From: Juan Baeza <Juan.Baeza@arun.gov.uk>
Sent: 18 October 2019 09:02
To: Planning.Responses <Planning.Responses@arun.gov.uk>
Subject: FW: Gladwyn

Subject: Gladwyn

The applicant has just been in touch saying she would prefer to go the route of allocated parking i.e. 2 per house and 3 casual spaces. I hope this doesn't create a problem.

Project: Proposed new homes; Gladwyn, The Street, East Preston BN16 1HT			
Drawing: Block plan, bin store elevations			
For: Mrs. J. Simmonds & Mr. P. Beamish			
Drawn: PKS		Date: November 2018	
Scales: 1:50 1:200		No: 2386/01/03/C	
To scale when printed on A3

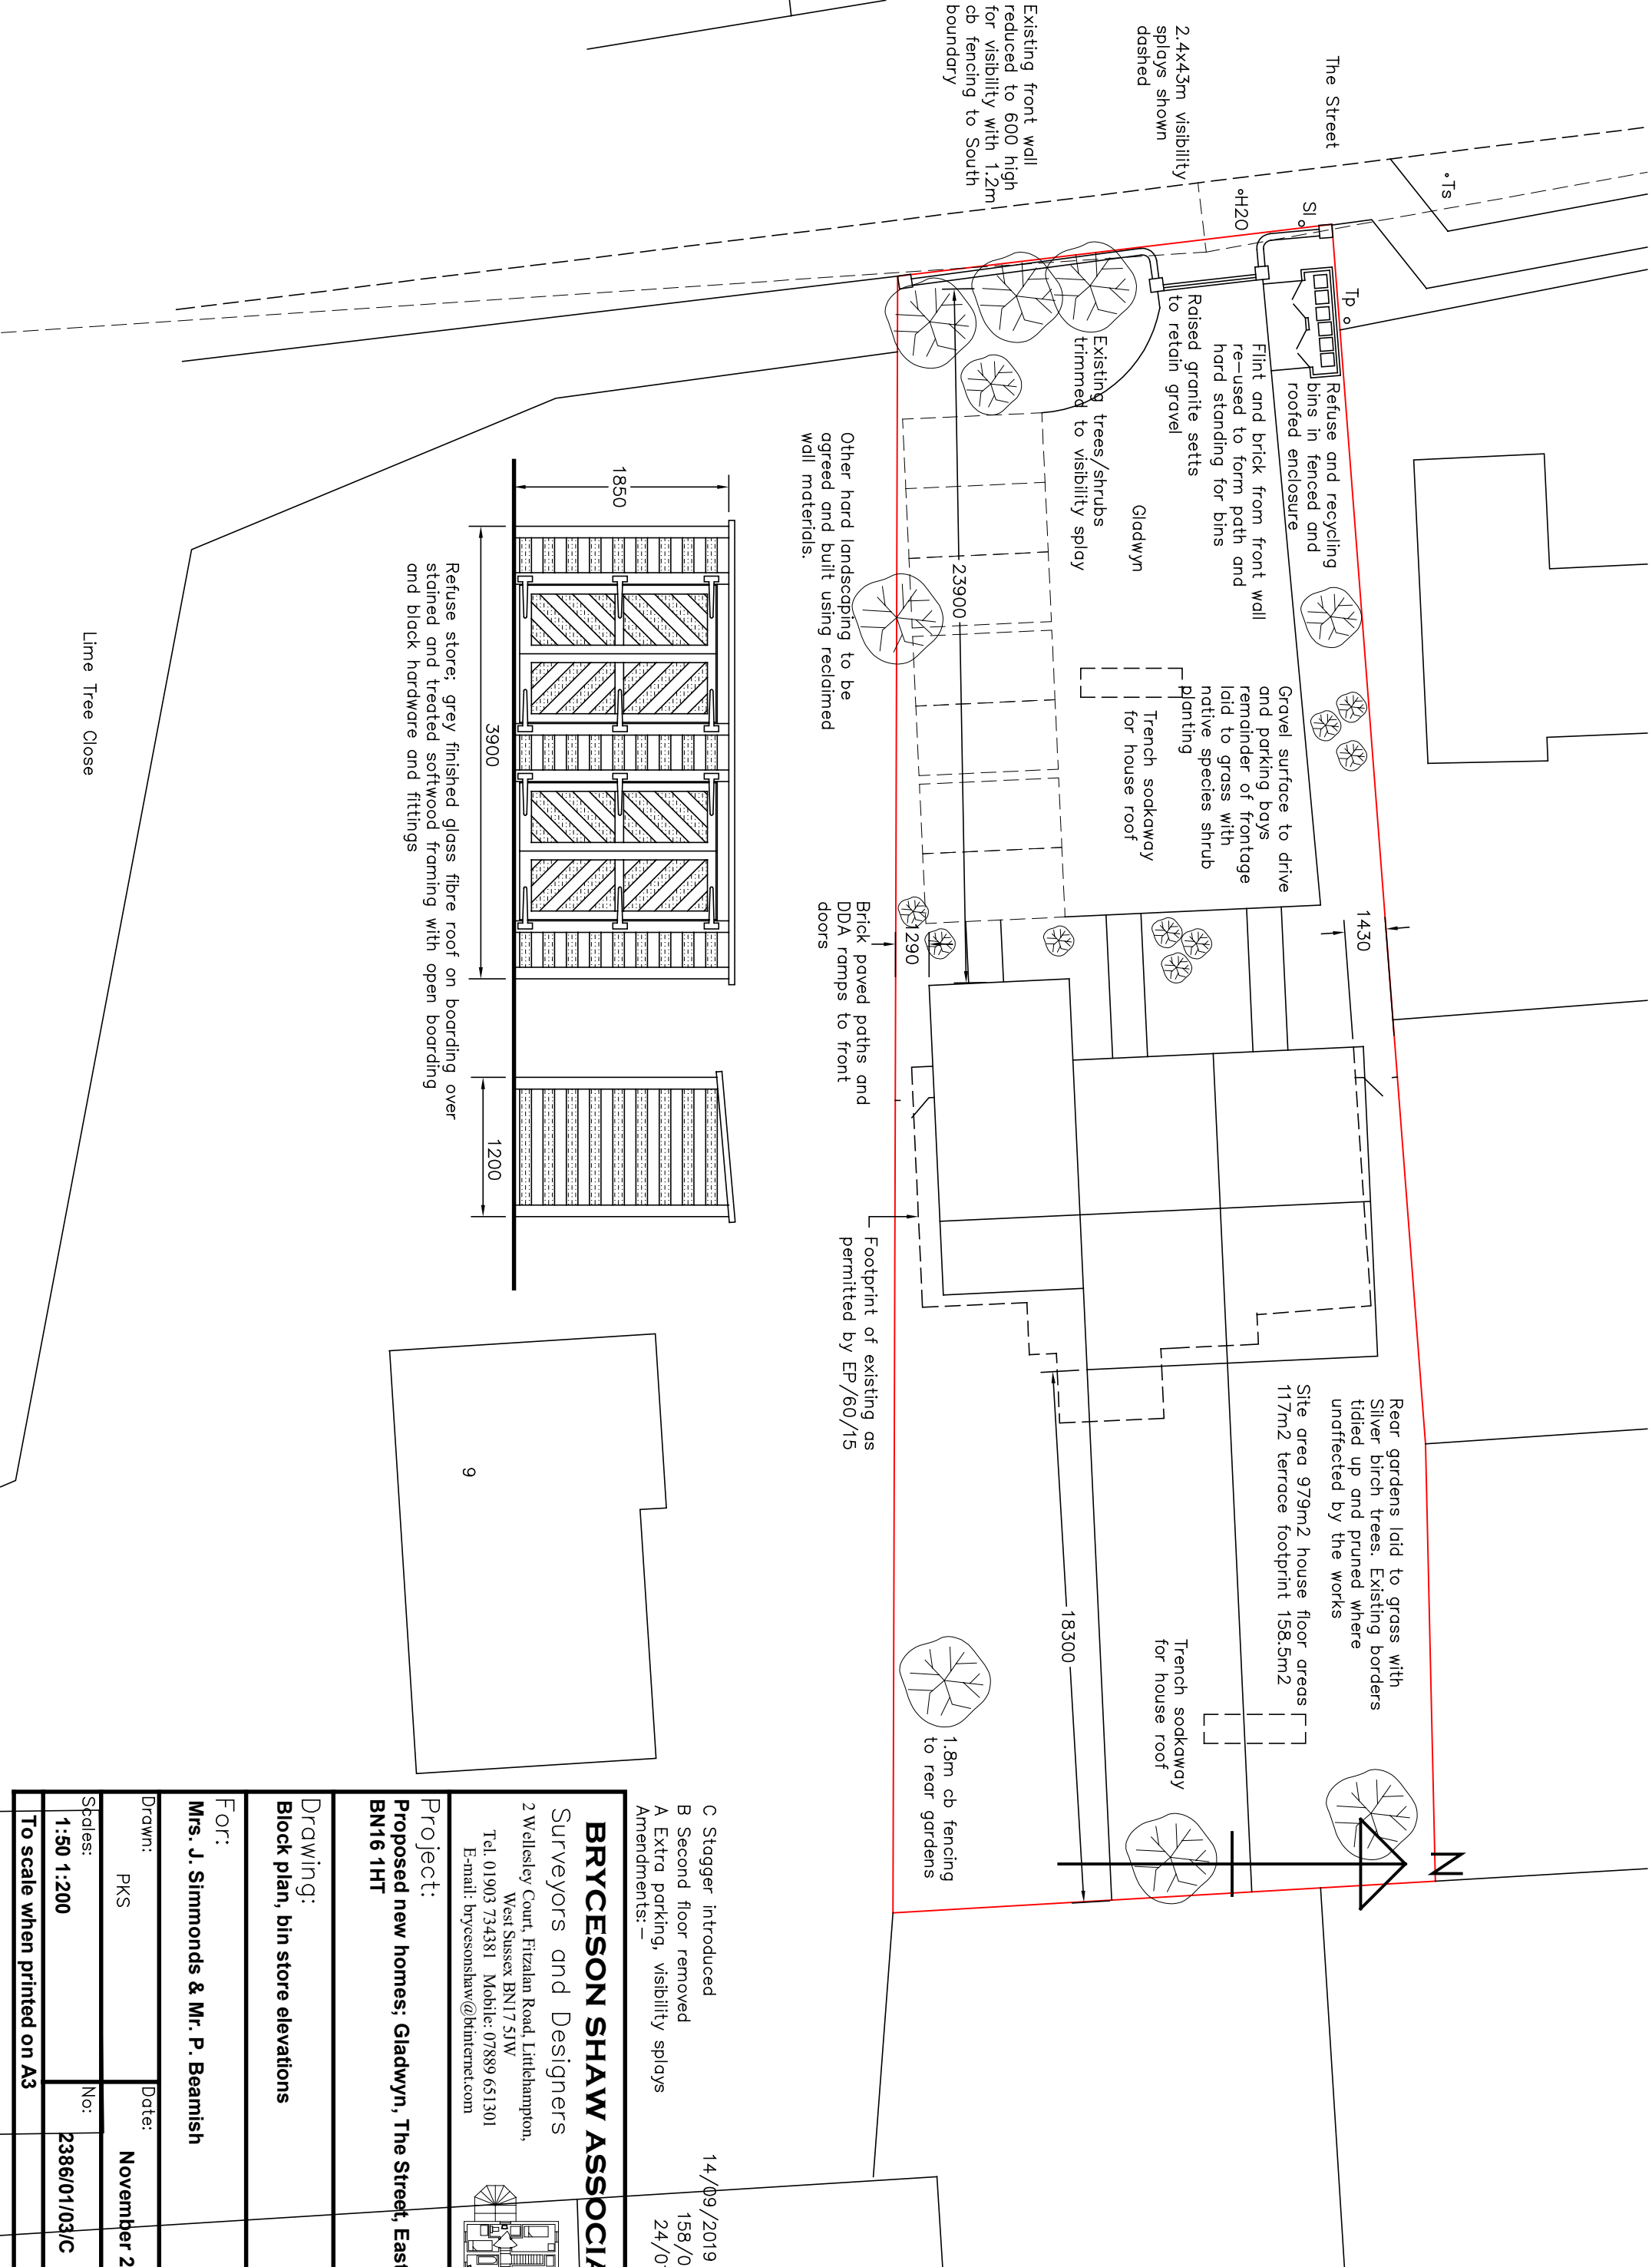
No, this would not alter my comments as the PDC expects 9 spaces if allocated, which the below proposed arrangement meets.
